**Re: AAA Building and Storage
2509 Comanche Rd. NE
Grading & Drainage Plan
Engineer's Stamp dated: 11-14-16 (G16D004)**

Project Title: AAA ROOFING STORAGE SPACE Building Permit #: _____ Hydrology File #: G160004

**Re: AAA Roofing Storage space
2509 Comanche RD NE
Traffic Circulation Layout
Architect's Stamp 11-09-16 (G16-D004)**

SITE PLAN / TRAFFIC CIRCULATION LAYOUT SCALE: 1/16" = 1' - 0"

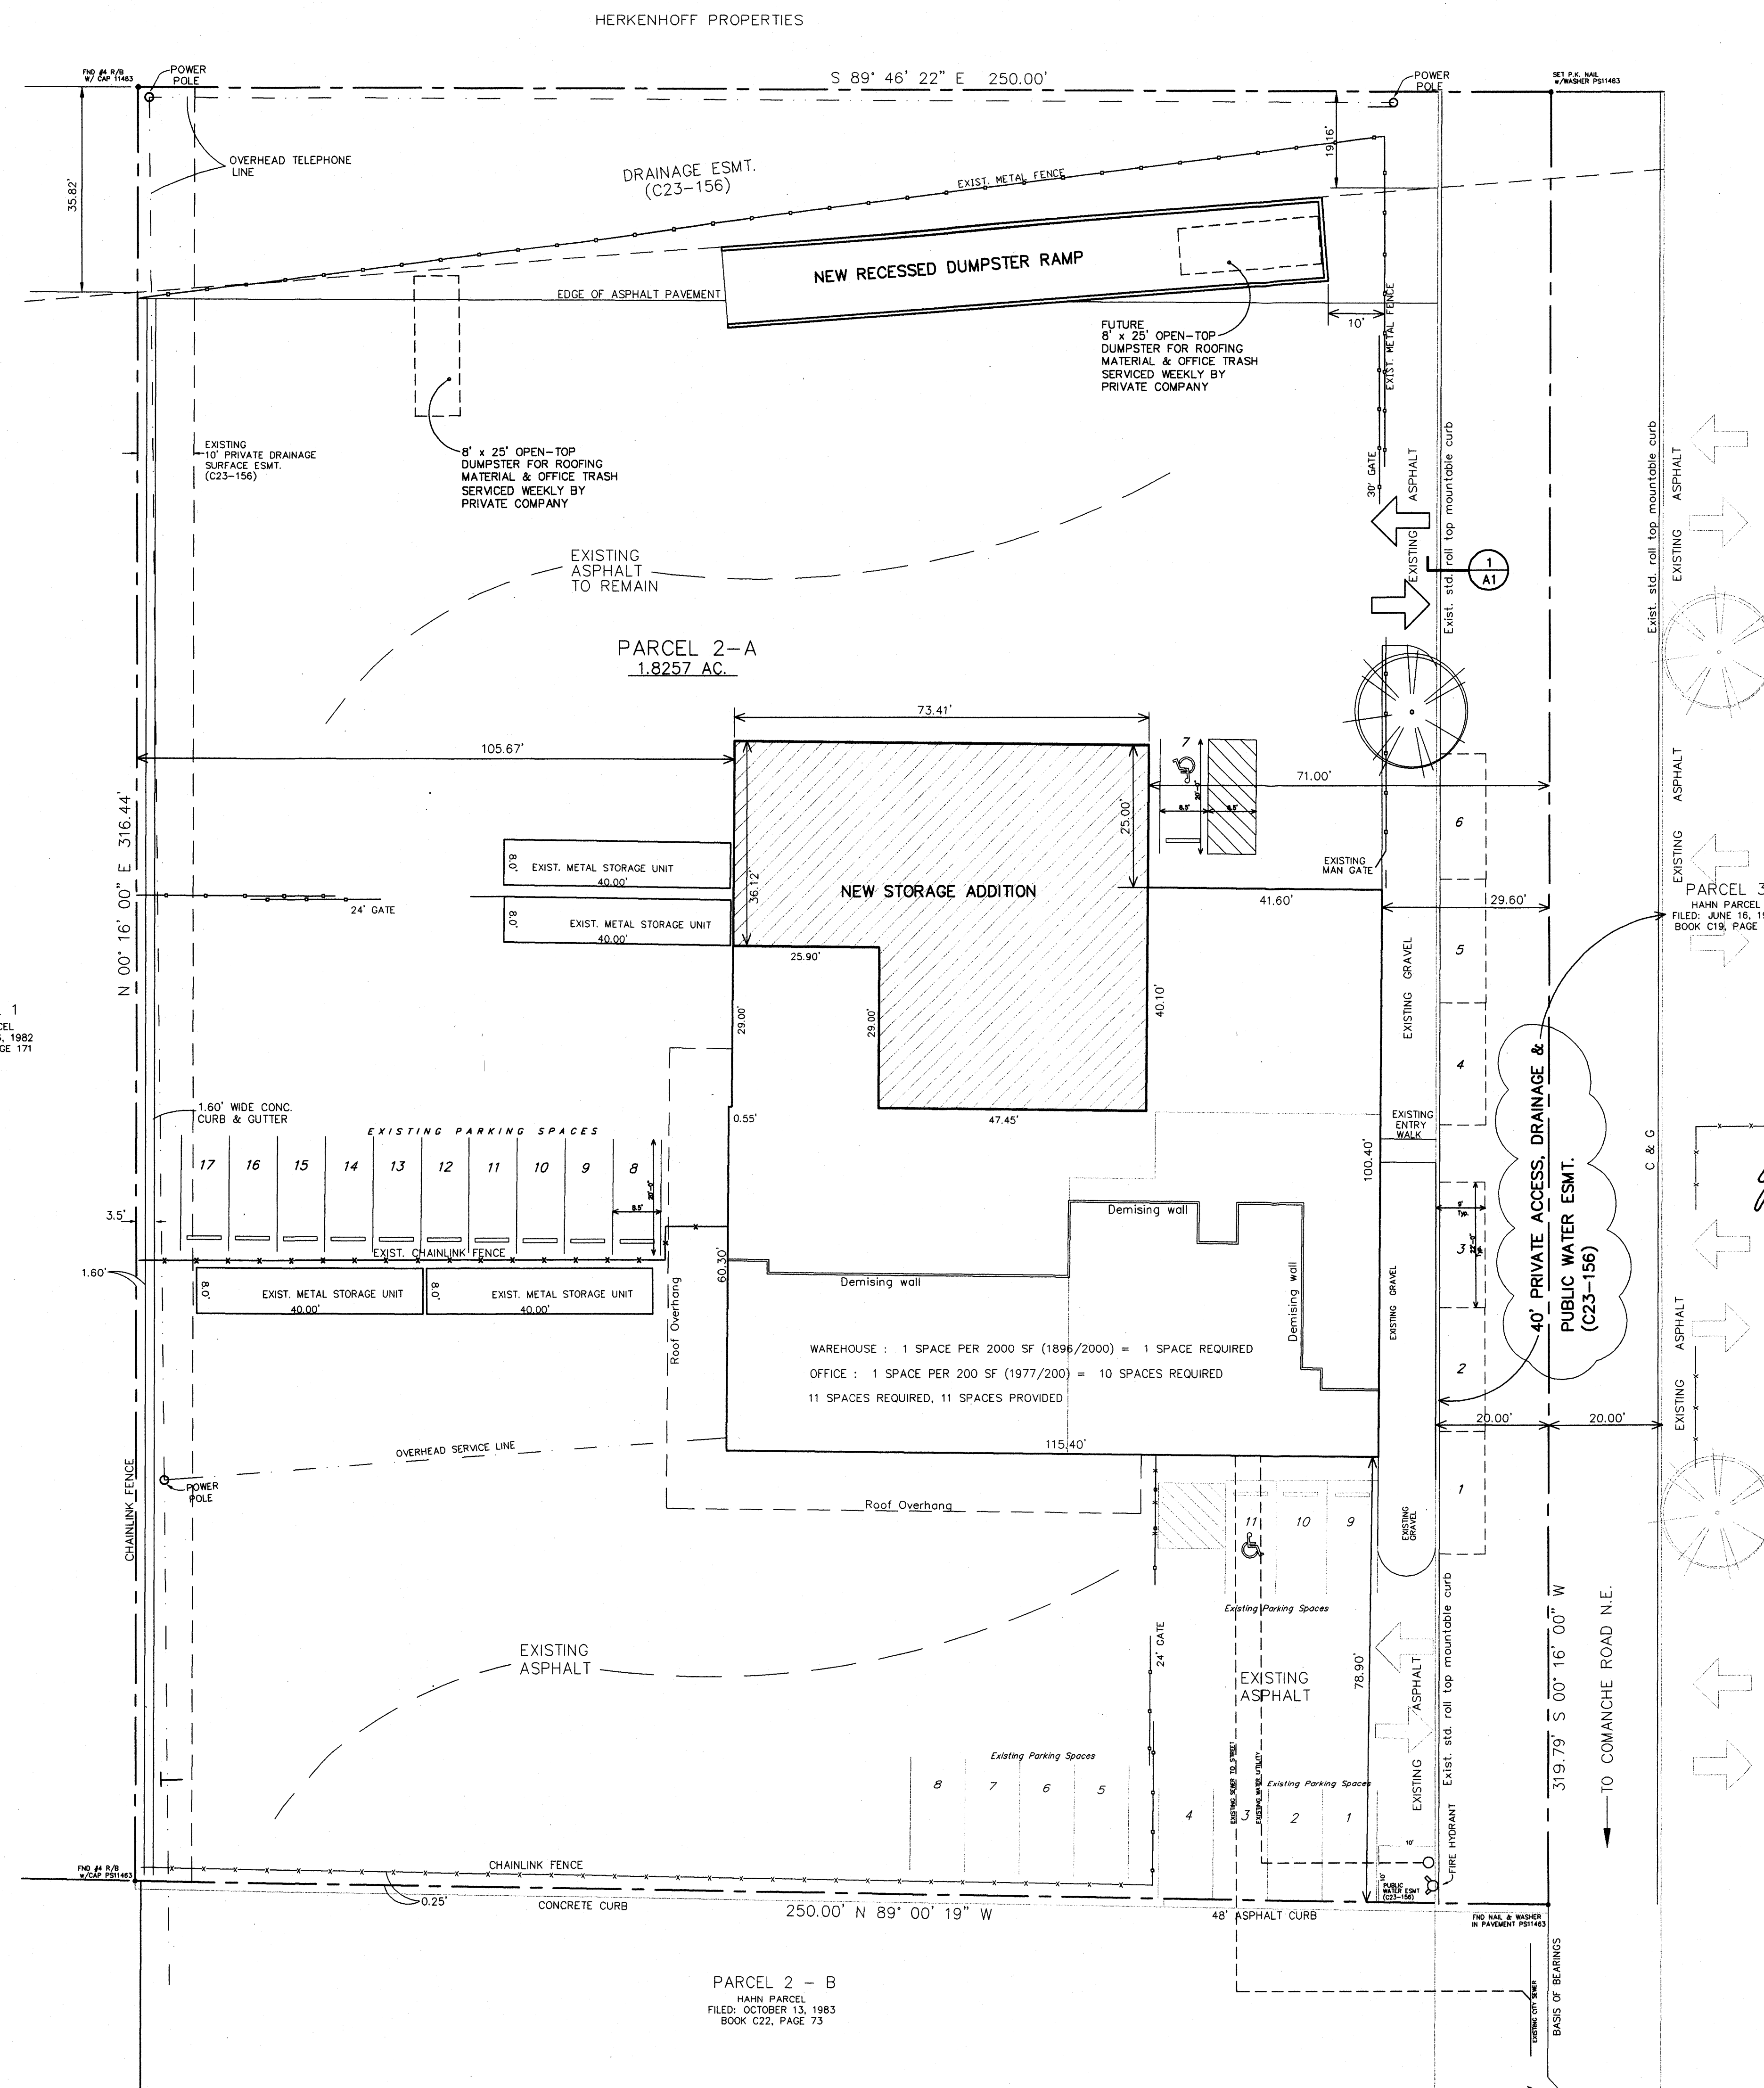
1. Please identify all accessible building entrances, drive entrance widths and anything that influences the parking and circulation on the site.
2. Please list the width and length for all existing and proposed parking spaces. Some dimensions are not shown. Indicate if existing parking will be restriped. Will the existing handicap parking remain? If so, it should be updated.

3. The ADA accessible parking sign must have the required language per 66-7-352.4C NMSA 1978 **"Violators Are Subject to a Fine and/or Towing."** Please call out detail and location of HC signs.

4. The ADA access aisles shall have the words **"NO PARKING"** in capital letters, each of which shall be at least one foot high and at least two inches wide, placed at the rear of the parking space so as to be close to where an adjacent vehicle's rear tire would be placed. (66-1-4.1.B NMSA 1978)

5. Per DPM, a 6 ft. wide ADA accessible pedestrian pathway is required from the HC parking stall access aisles to the building entrances. Please clearly show this pathway and provide details.
